# KITTITAS COUNTY

## DEPARTMENT OF PUBLIC WORKS

### MEMORANDUM

**TO:** All Staff  
**FROM:** Public Works Plan Review Team  
**DATE:** June 16<sup>th</sup>, 2023  
**SUBJECT:** Public Works Comments: SP-23-00003 Hauglum

HAUGLUM SHORT PLAT PART OF SECTION 34, T. 20 N., R. 15 E., W.M. KITITAS COUNTY, WASHINGTON

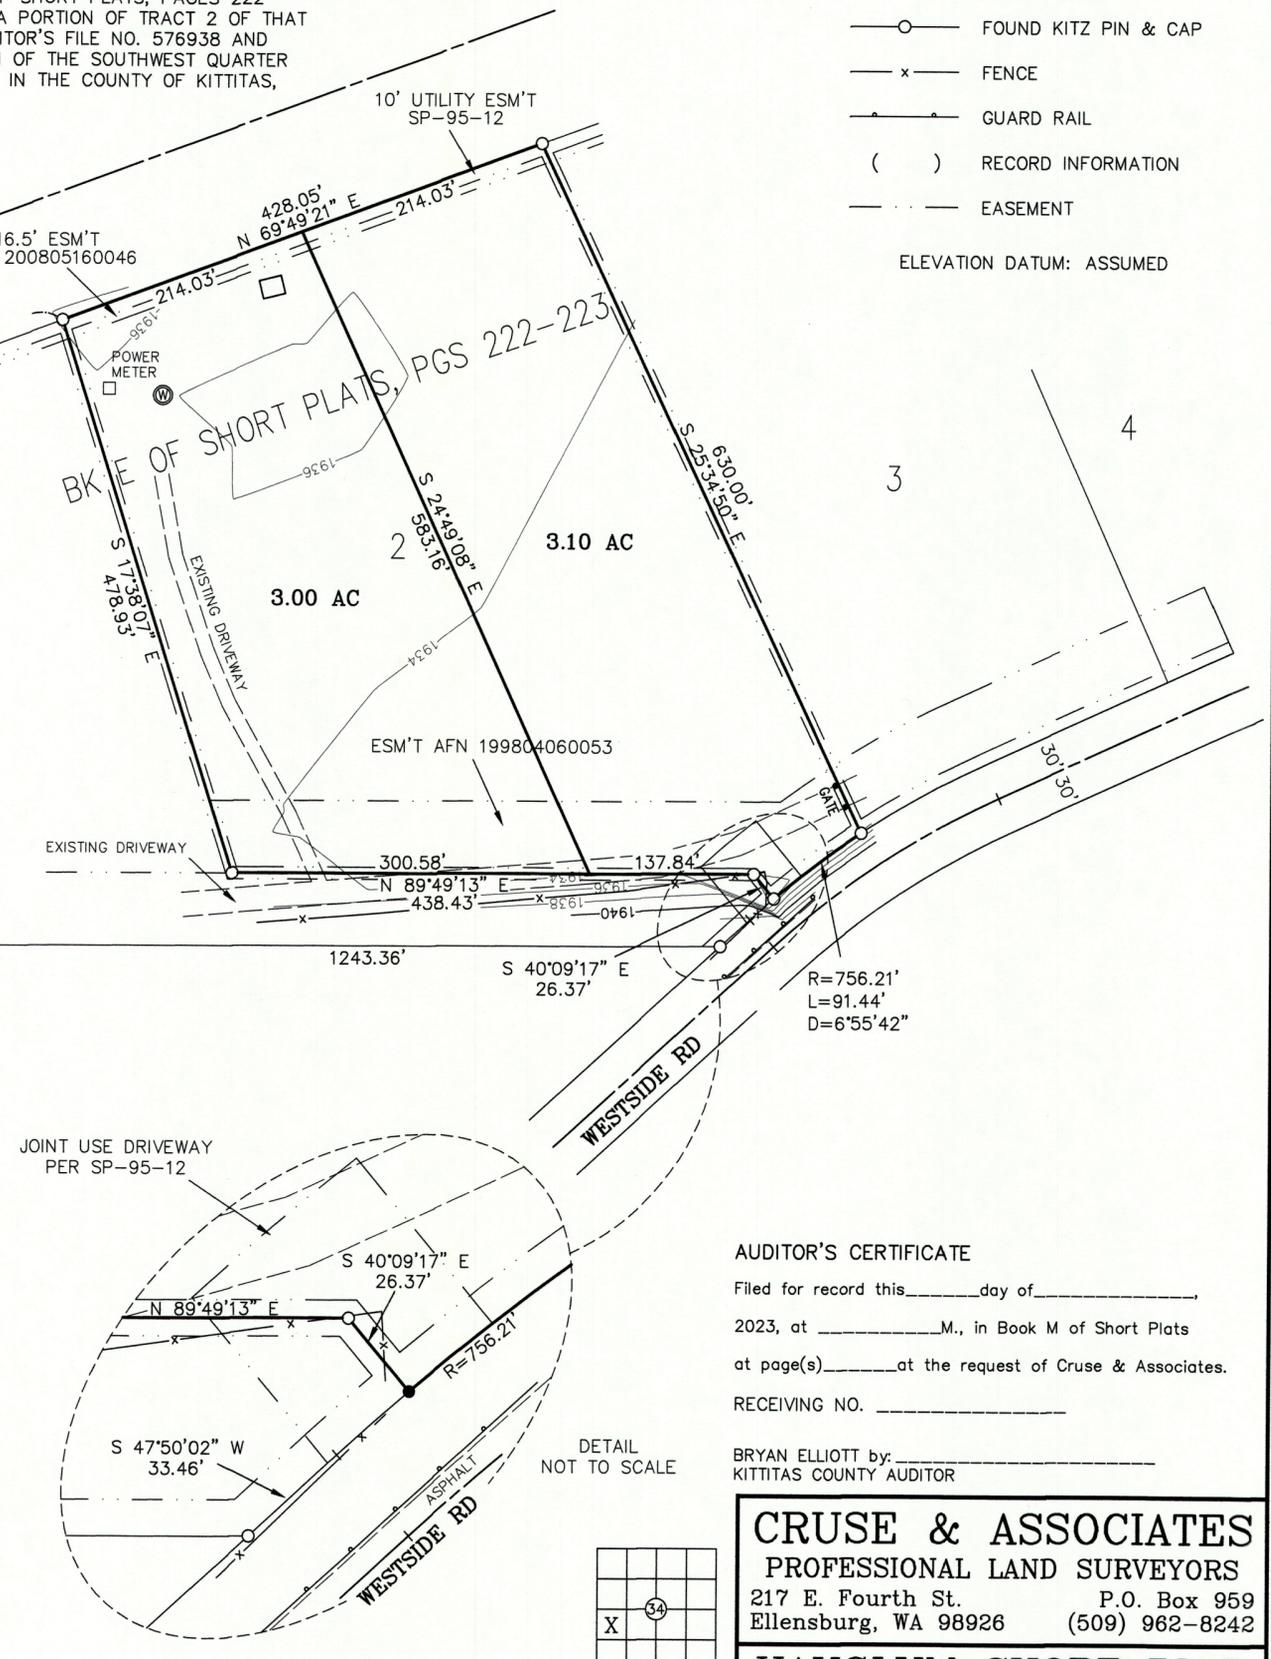
<b>SURVEY</b>	<ol style="list-style-type: none"> <li>1. The Prelim Short Plat provided does not meet the requirements of WAC 332-130-145. Survey proposes a resubmittal that addresses these requirements.</li> <li>2. Per Compass GIS map, there are multiple structures on site that do not appear on the face of the Short Plat. In the event these were removed, a statement from the surveyor will be sufficient.</li> </ol> <p>Prior to final approval, the following elements will need to be addressed:</p> <ol style="list-style-type: none"> <li>1. The joint use driveway easement should reference Volume and Page or AFN, not CDS's application number.</li> <li>2. The S'most found property corner shown has a break in the distance ties. Please include the missing curve data, so that this is tied to the survey. Doing this will eliminate the need for comment #3 below.</li> <li>3. As the Curve coincident with the North line of Westside road is non-tangential, please include a chord bearing and distance OR show the bearings of radii at start and end of the curve. (JT)</li> </ol>
